January 5, 2026

**RE: *Albuquerque School of Excellence
5200 & 5310 Sequoia Rd NW
Erosion and Sediment Control Plan: G11E048/ SWQ-2025-00041***

COMMENT RESPONSE LETTER

SHEET NUMBER
C3.0

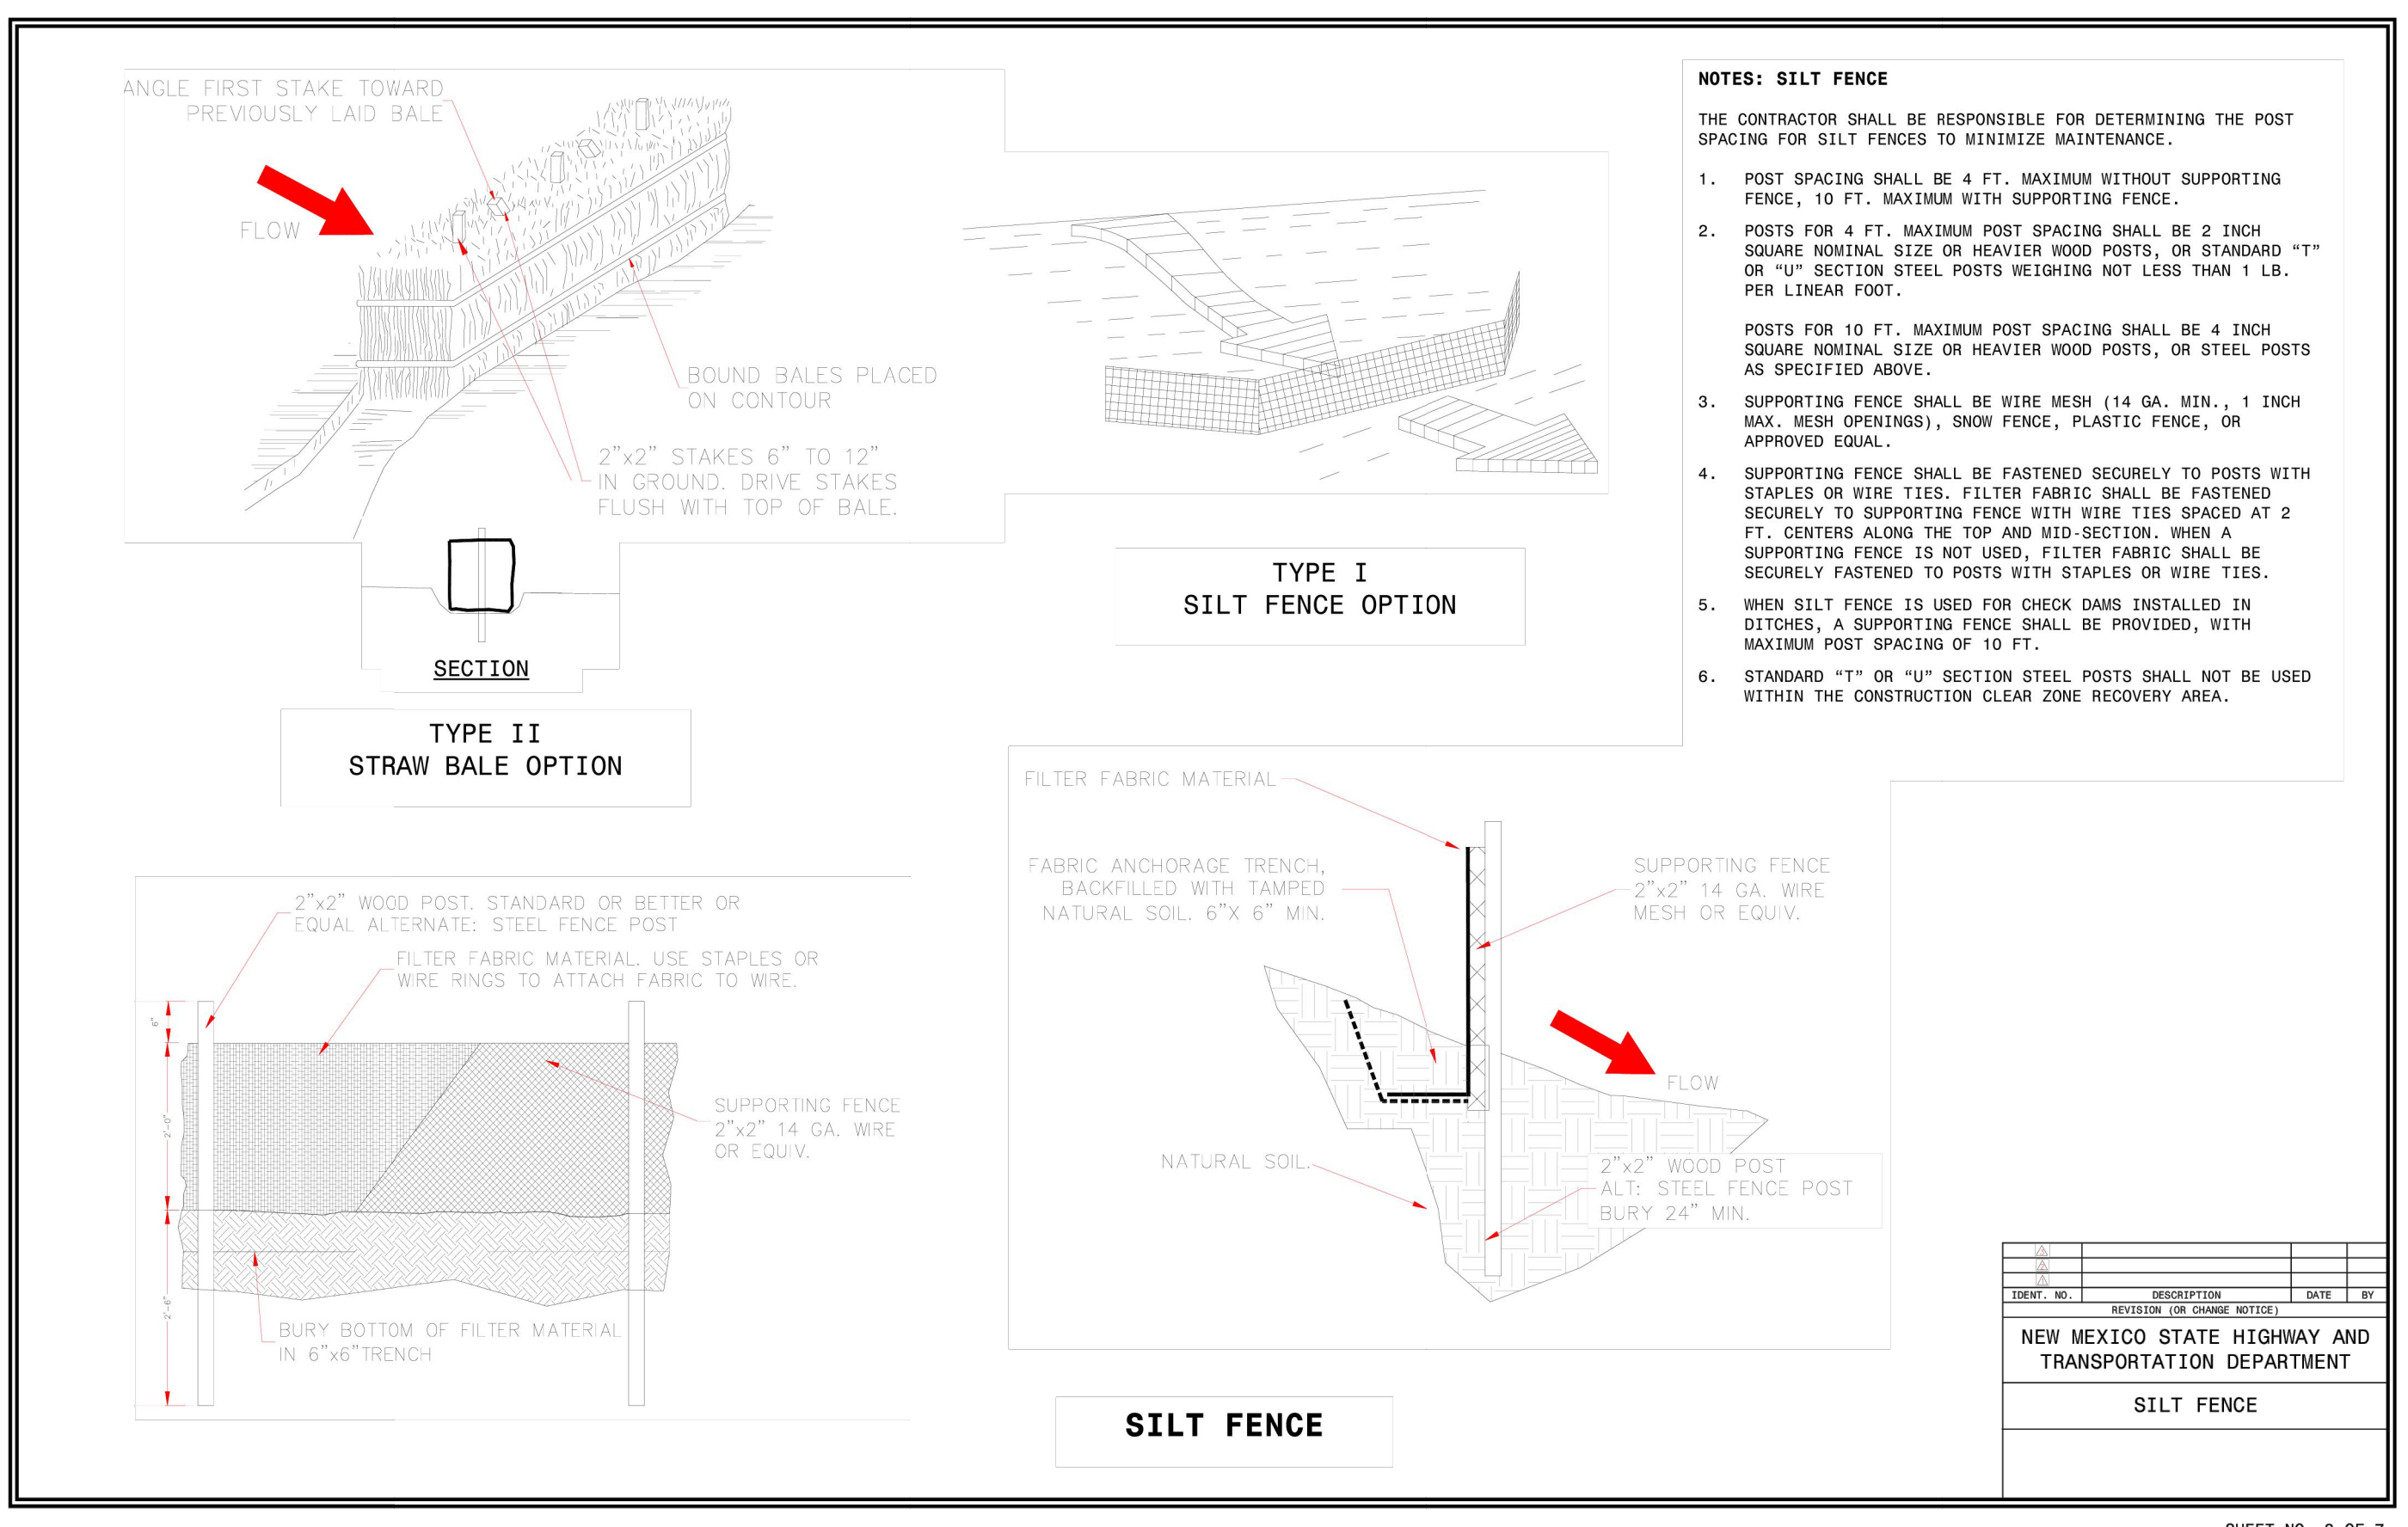
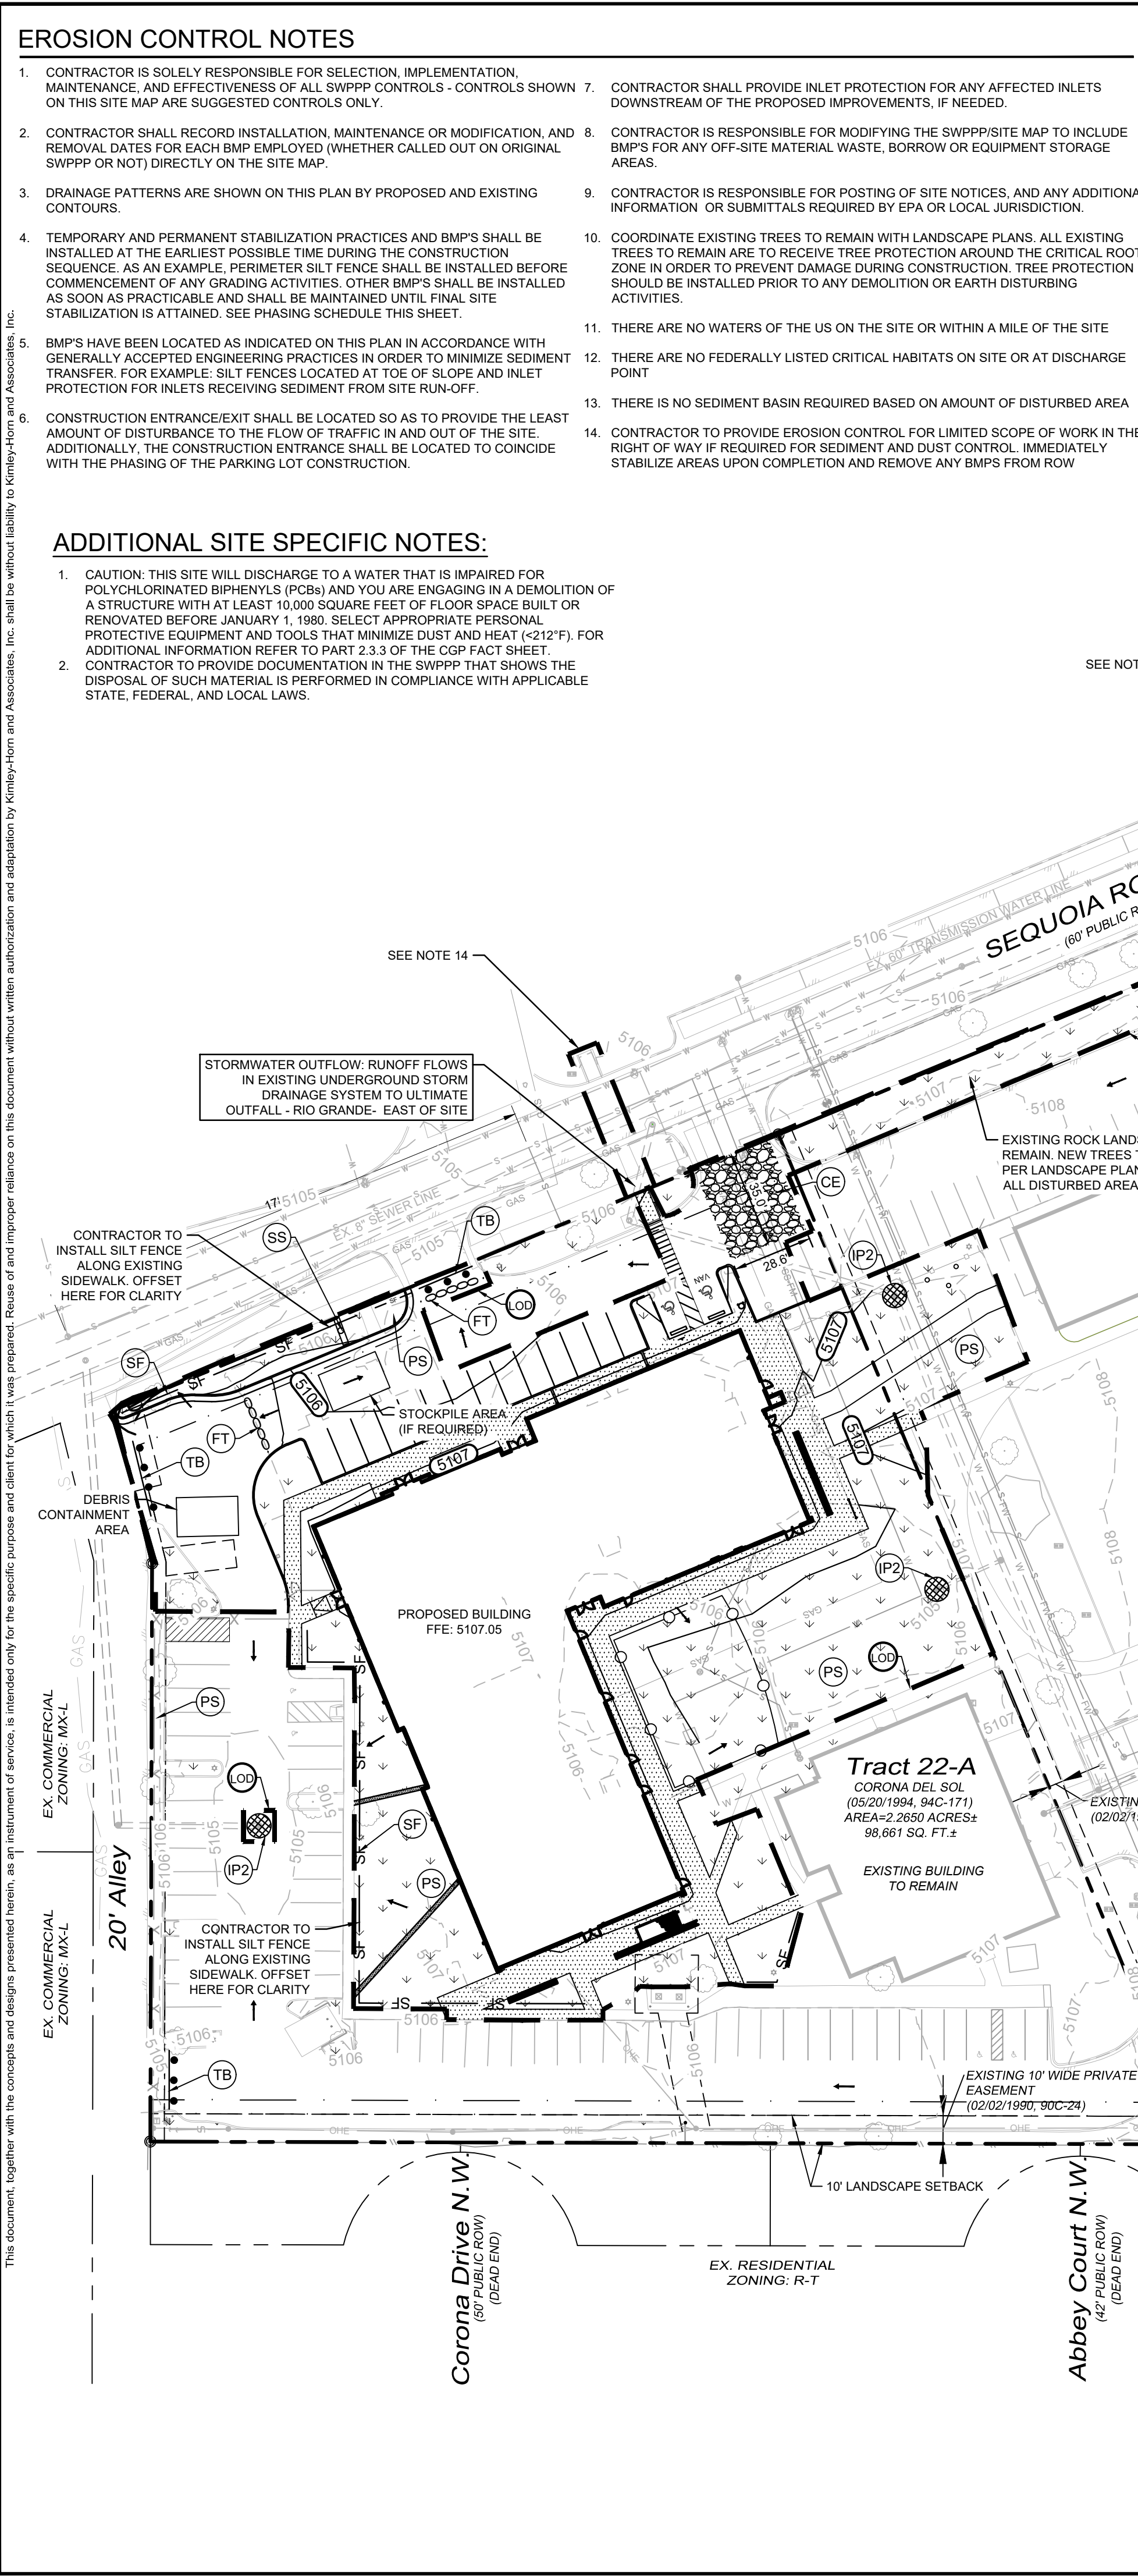
Response: This requirement has been added as note 15 to the ESC notes and noted next to the debris containment area on the ESC plan.
3. Note #11 of the Additional Site-Specific Notes says "there are no waters of the us on the site or within a mile of the site," when they are less than a half mile from the site. The note must be corrected and identify if any of these receiving waters are listed as impaired, per CGP 7.2.4. The ESC Plan must also show the Locations of all receiving waters within one mile downstream of the site's discharge point(s).
